CITY OF ALBUQUERQUE

RE: **5501 Bell SE**
Grading Plan
Engineer's Stamp Date 7/6/17 (File: L18D082)

RE: **5501 Bell SE**
Grading Plan
Engineer's Stamp Date 6/21/17 (File: L18D082)

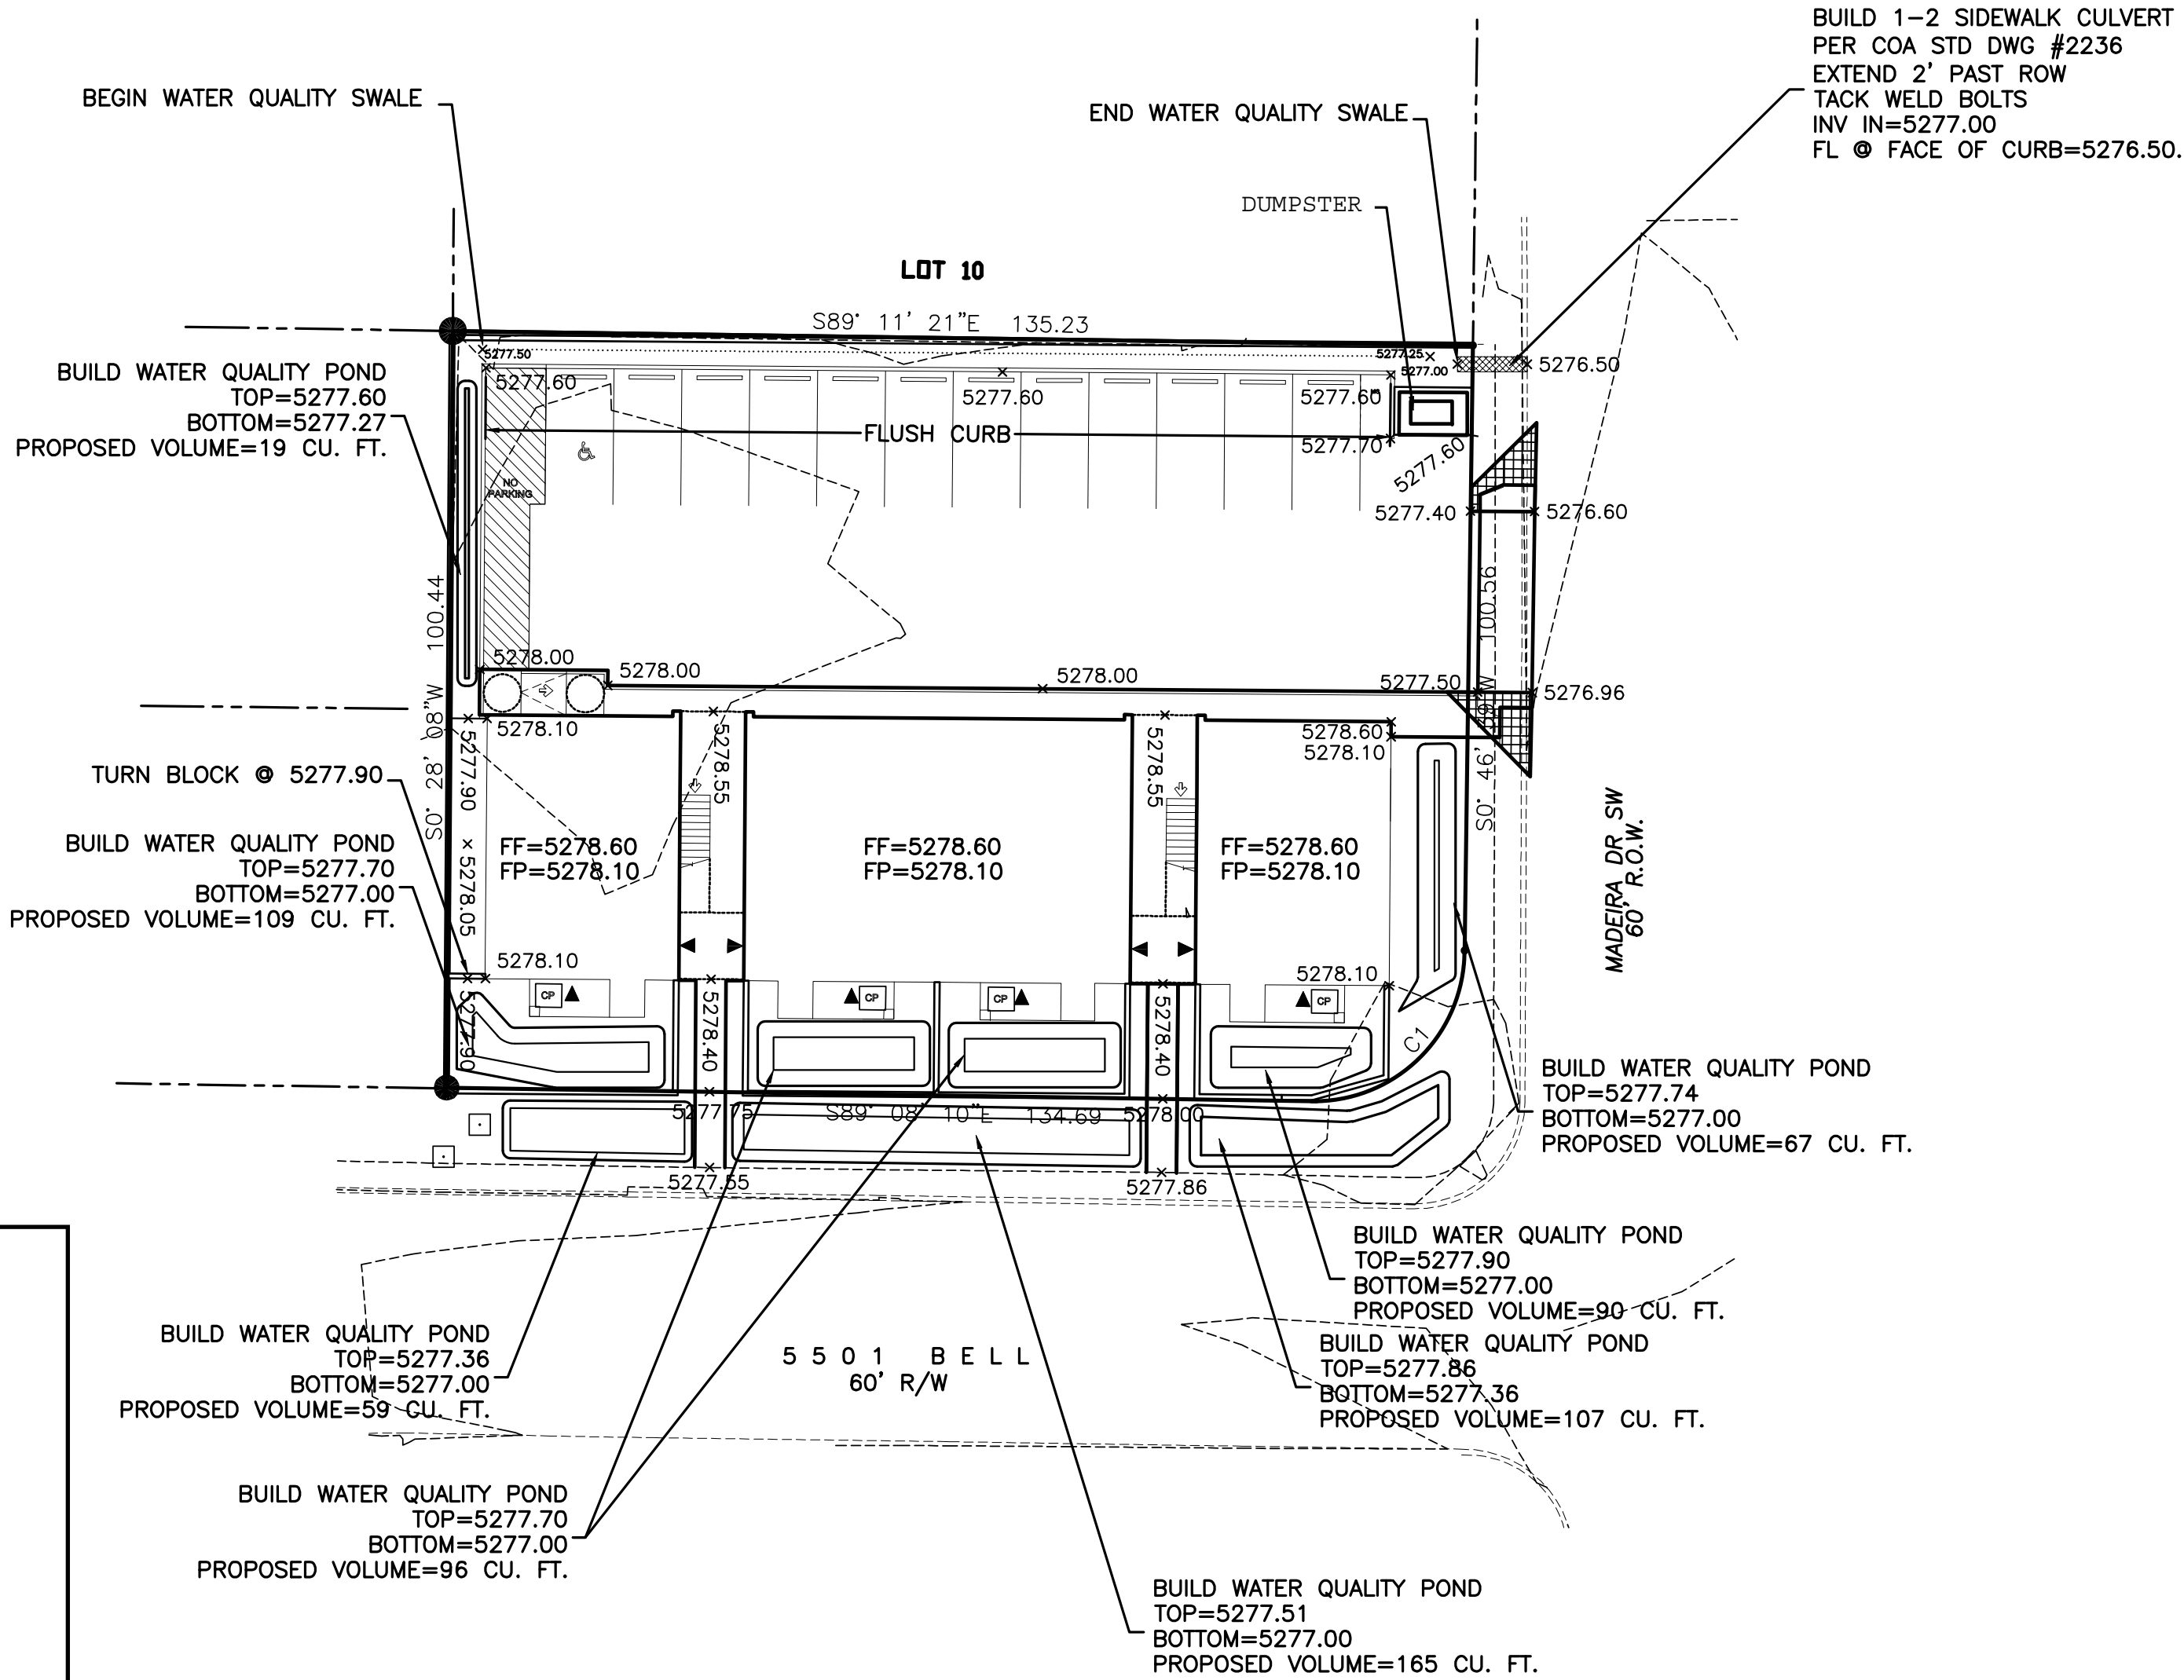
1. This site requires a Flood Plain Permit, submitted to Rudy Rael (rrael@cabq.gov), for grading work in the flood plain.
2. Provide project benchmark information.
